## SSD 7684 – COCKLE BAY, FURTHER INFORMATION REQUEST

We refer to your emails of 17 August 2018 and 6 September 2018 requesting additional information in relation to the above SSD application. A consolidated response to your queries are provided in the below table.

ATTACHMENT B  
VEHICLE TURN PATHS

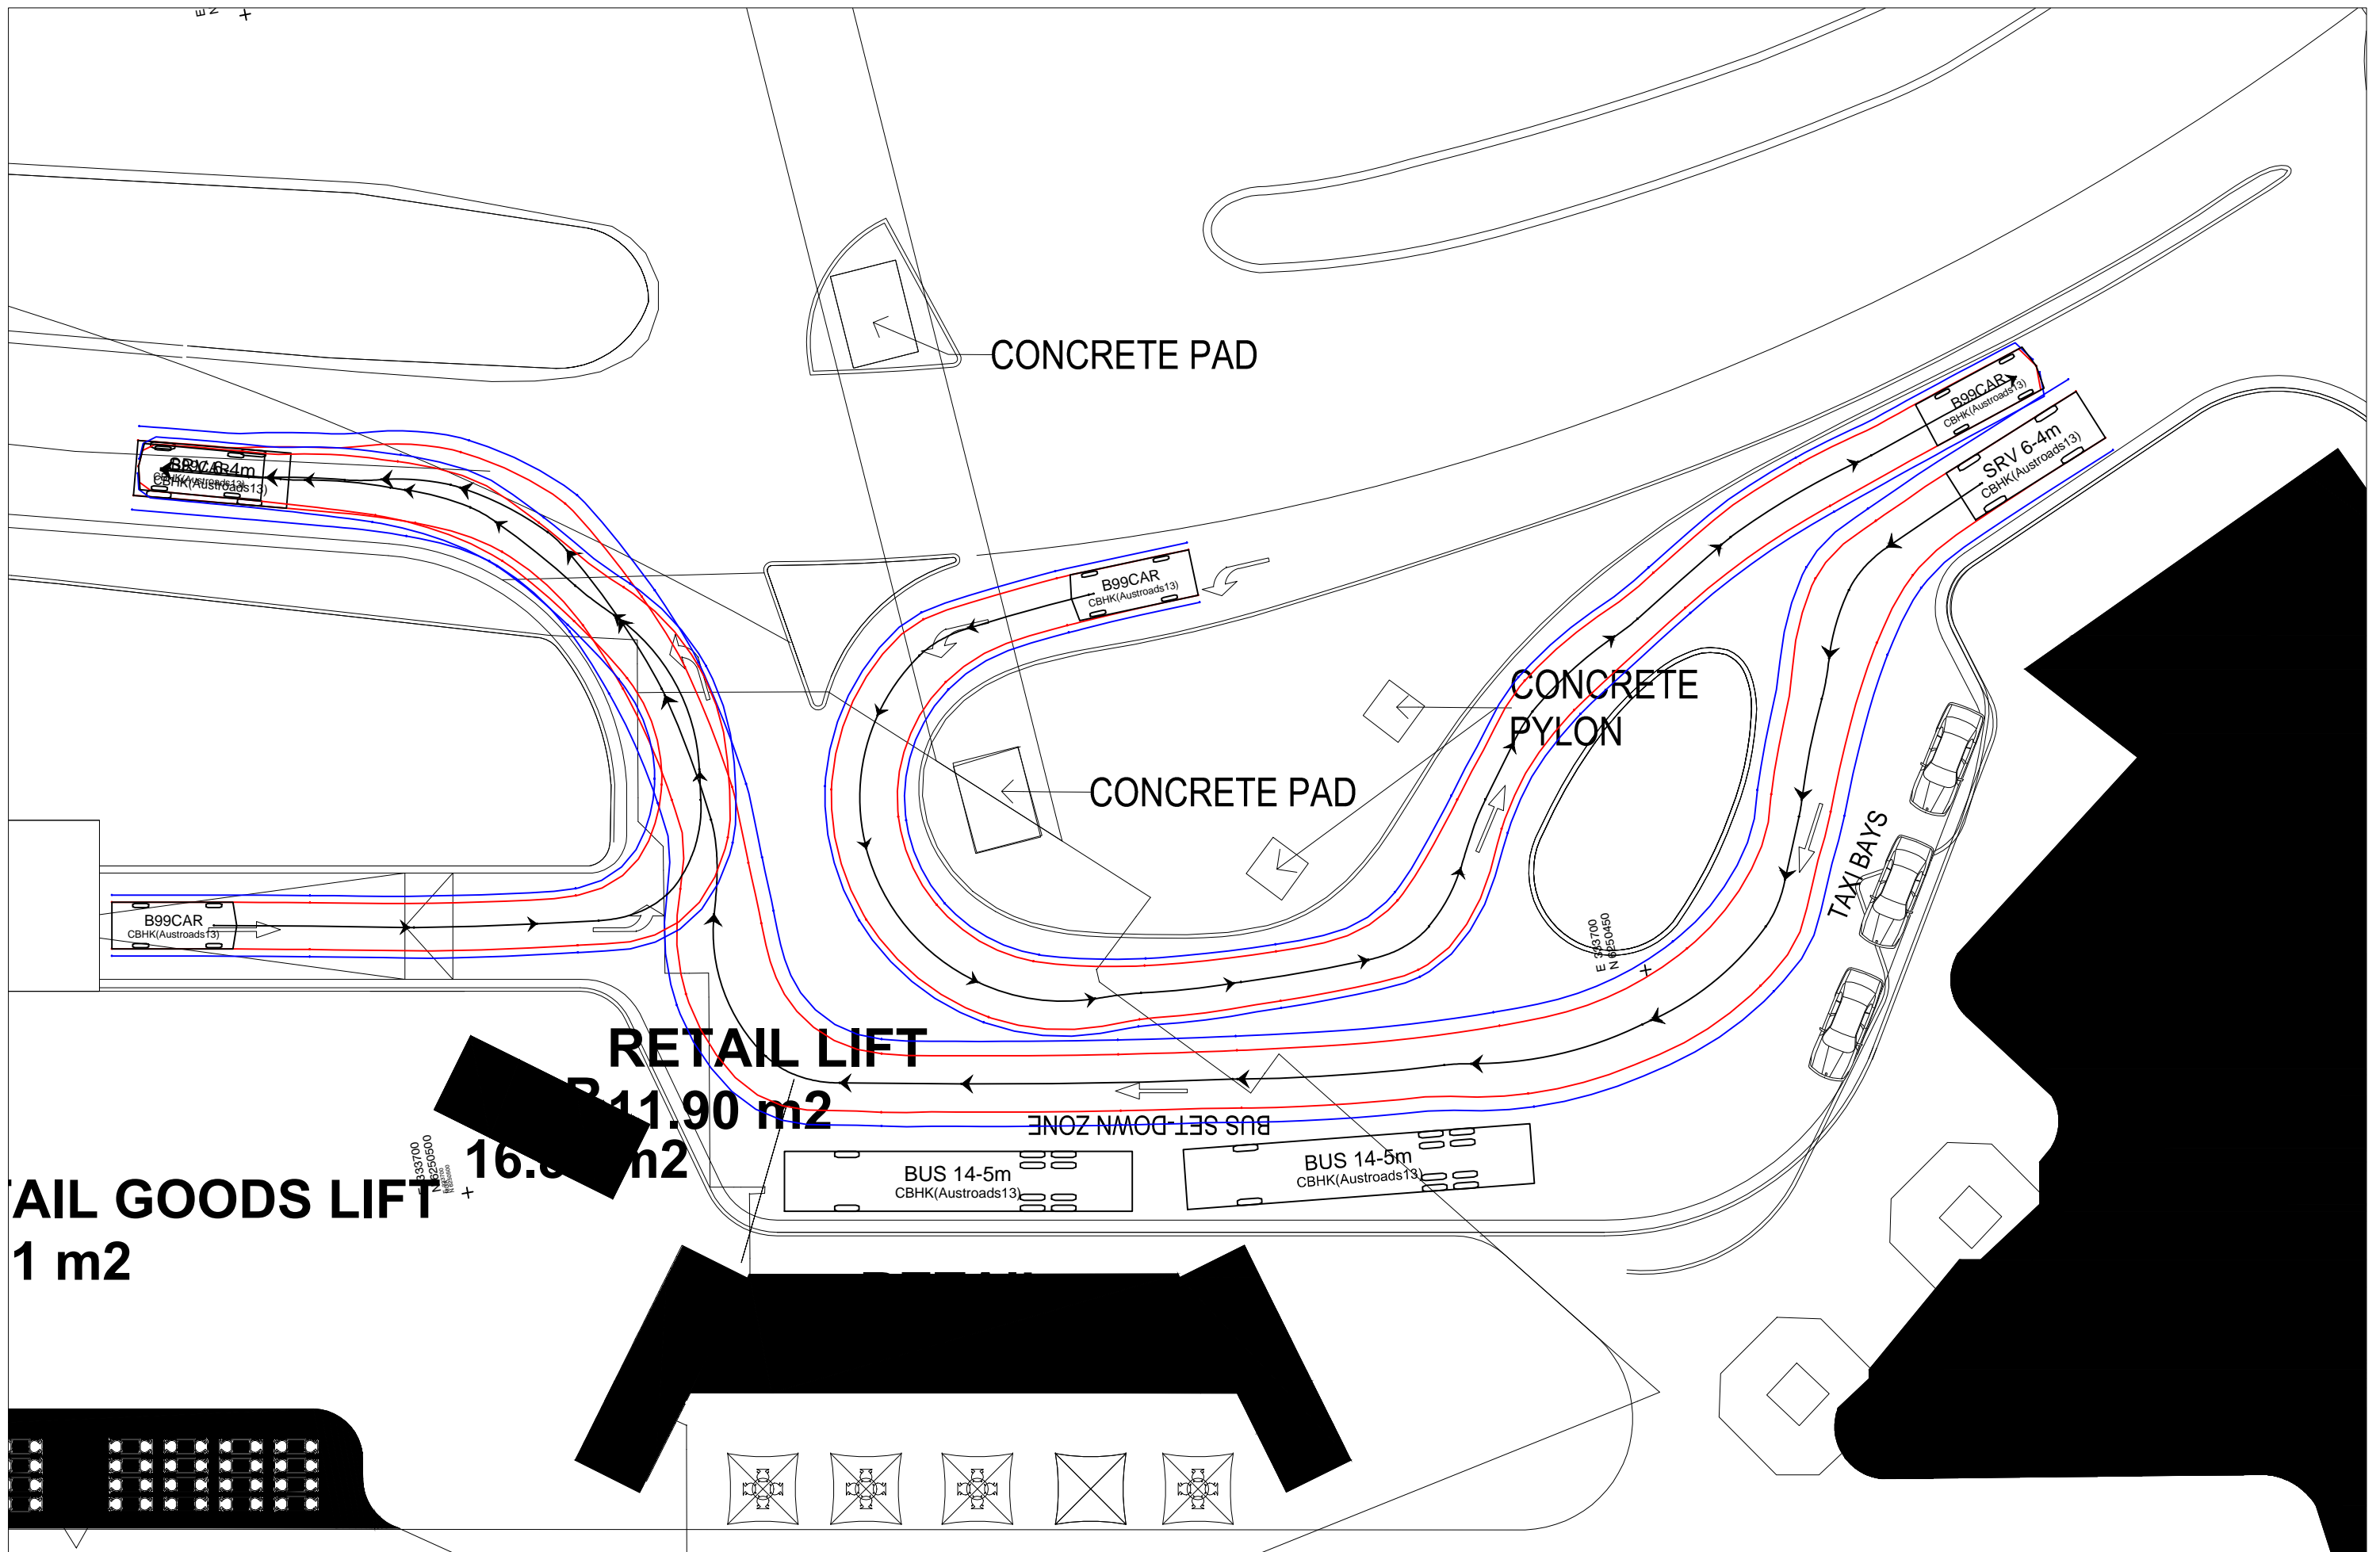
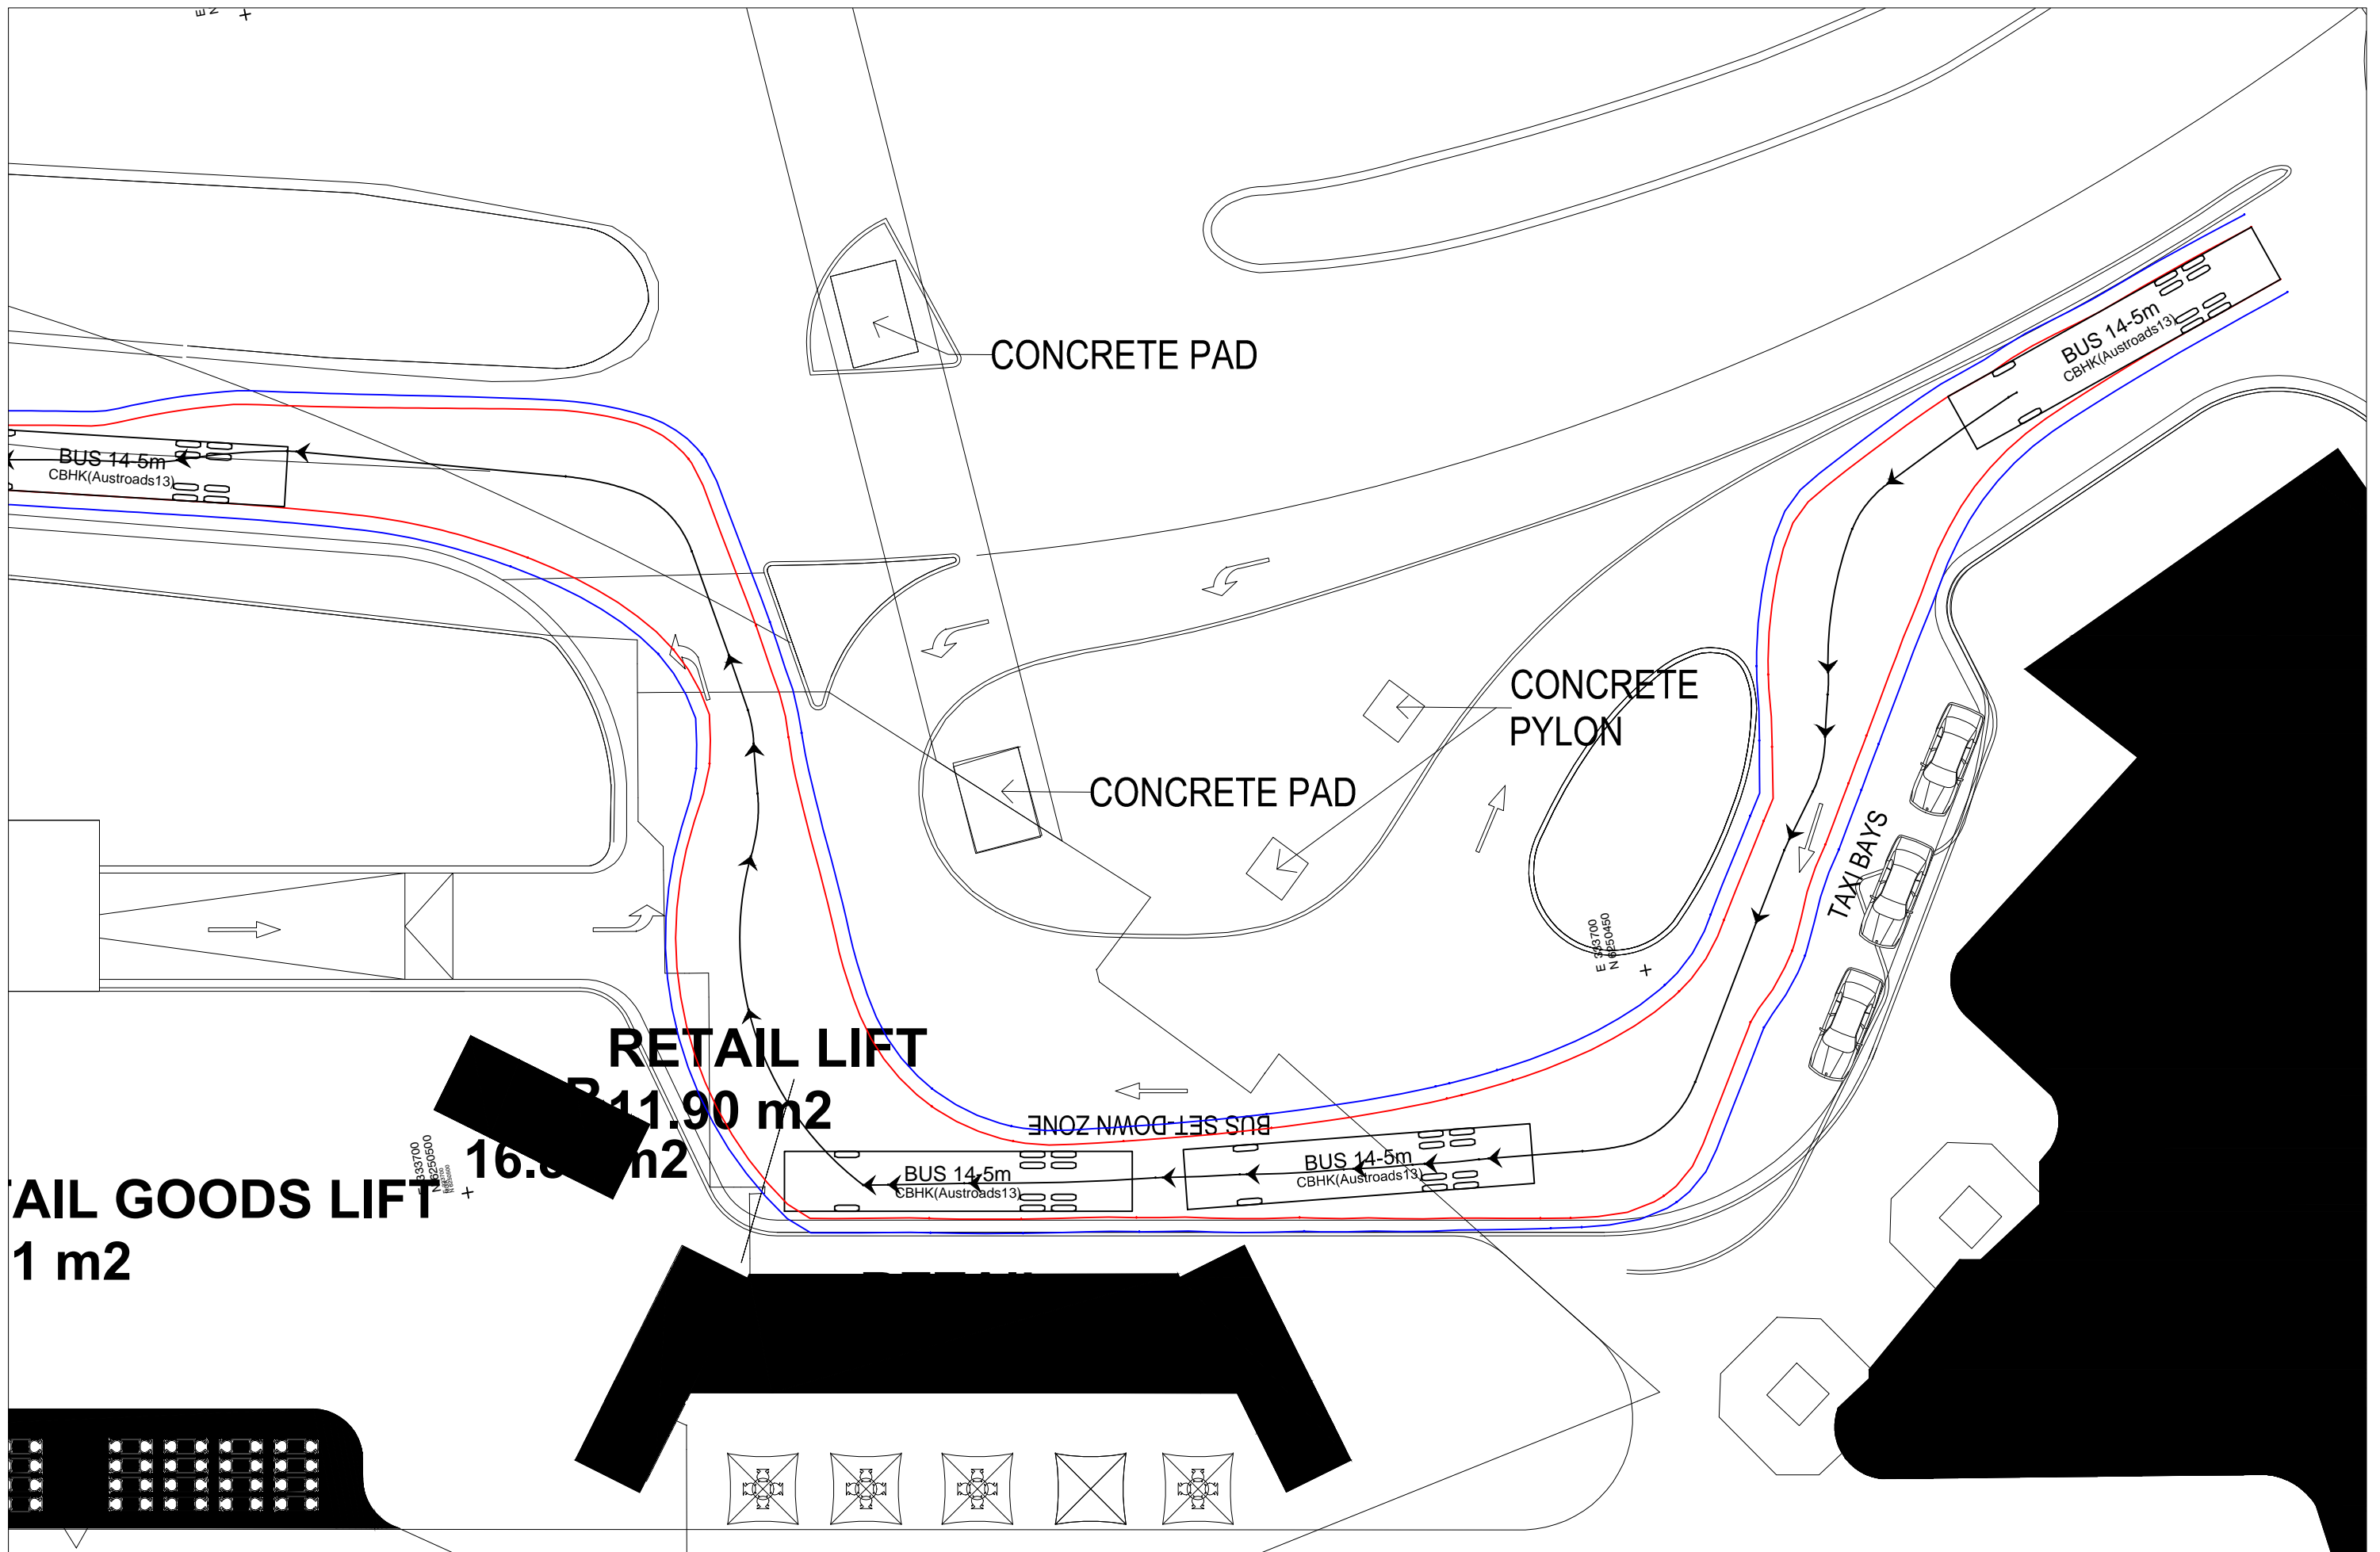
8	Provide updated vehicle swept path analysis for the southern access. It is noted the current diagrams relate to 'Base Case + Option 2', which is no longer proposed	An updated vehicle swept path 'Base Case' and 'Option 1' has been prepared by Aurecon and is provided at <b>Appendix C</b> .
9	Provide evidence the proposal does not conflict with the approved updated design of the IMAX port cochere.	<p>Please refer to the civil plans prepared by Aurecon at <b>Appendix C</b>.</p> <p>It is noted that Interface Design meetings were held with The Ribbon on the following dates 29/8/2017, 6/9/2017 and 29/9/2017 at The Ribbon's Site office.</p> <p>It is noted that both options proposed for the southern entry of the site align with current approved designs for the vehicular entrances of The Ribbon. Co-ordination has been conducted using Drawing no. ARC-HSL-DD-1100 RevN1, this being the latest stamped drawing for The Ribbon, dated 20/10/2017 stamped on the 2/11/2017 for MOD 3 SSD7388.</p>
